Ribble Valley Borough Council
Housing & Development Control

Your ref: 3/2023/1008
Our ref: D3.2023.1008
Date: 9th February 2024

Application no: **3/2023/1008**

Proposal: **Proposed refurbishment of existing ground-floor caretaker apartment and creation of four new holiday let apartments, three on the ground floor and one on the first floor.**

Application No:
 Local area council:
 Previous application No:
 Dwg : PCD00154
 Drawn: PCD

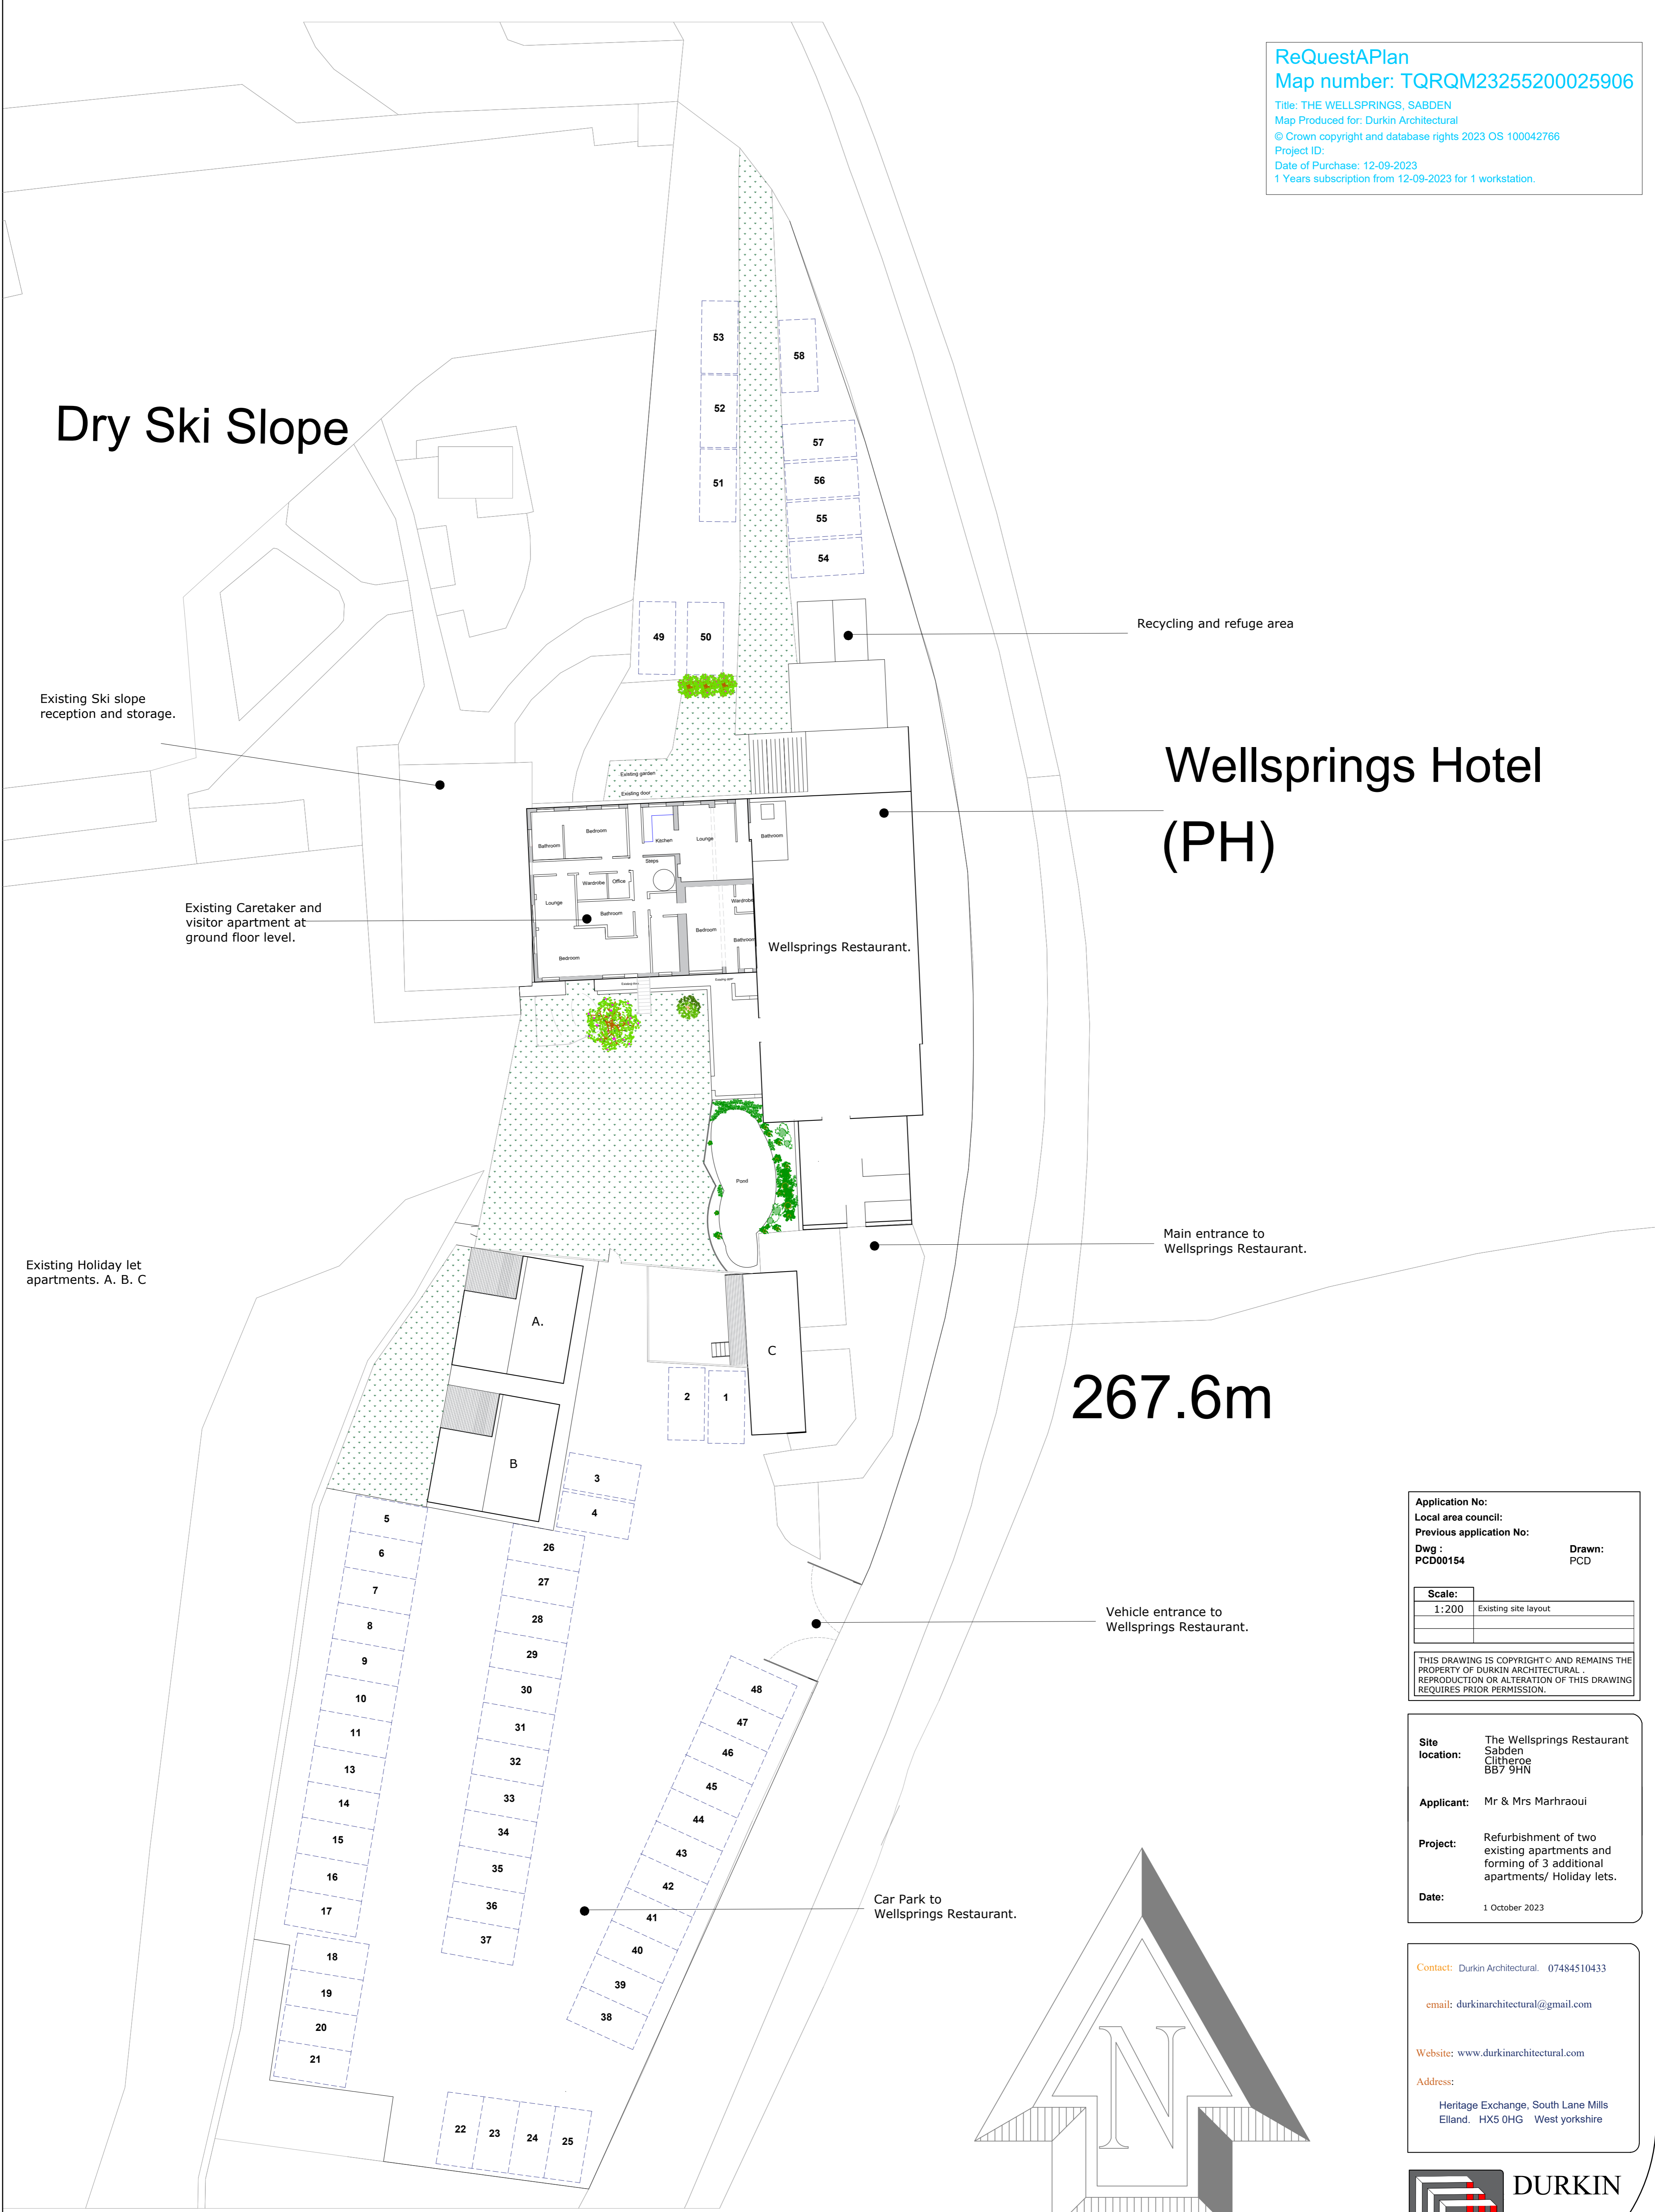
The site has two accesses which are located off Clitheroe Road, a C classified road subject to a 60mph speed limit. One of the accesses is used as a car park for the Wellsprings Restaurant and the three existing holiday lets providing 48 car parking spaces. While the other access provides upto 10 car parking spaces, as shown on Durkin drawing number PCD00154 titled "Existing Site Layout."

Given that the restaurant will operate at a reduced capacity following the proposal, the LHA require further information in the guise of an Operation Statement stating the existing and proposed covers the site can provide following the proposal. As well as the existing and proposed floor area of the restaurant. The LHA require this information because the site is aiming to use the car parking area, adjacent to the ski slope, which provides 10 spaces as a formal parking area for the proposed 4 holiday lets.

However, the LHA have reviewed Durkin drawing number PCD00154 and are unable to formalise this car parking area. This is because the area is quite narrow and does not provide any internal turning facilities to ensure that vehicles can exit the site in a forward gear. Therefore, the LHA are concerned that vehicles, following the formalisation of the area, will reverse out onto the high speed adopted highway which also has poor vehicular visibility due to the curvature of the road and the existing restaurant building obstructing visibility to the east.

Therefore, should the restaurant operate on a reduced capacity following the proposal and it constitutes that the restaurant will have adequate spare capacity on the existing car parking area for 4 holiday lets, the LHA will have no objection to the proposal. But the LHA will require that a parking plan showing 4 spaces designated for the 4 holiday lets are shown on the existing car park and the spaces should be lined.
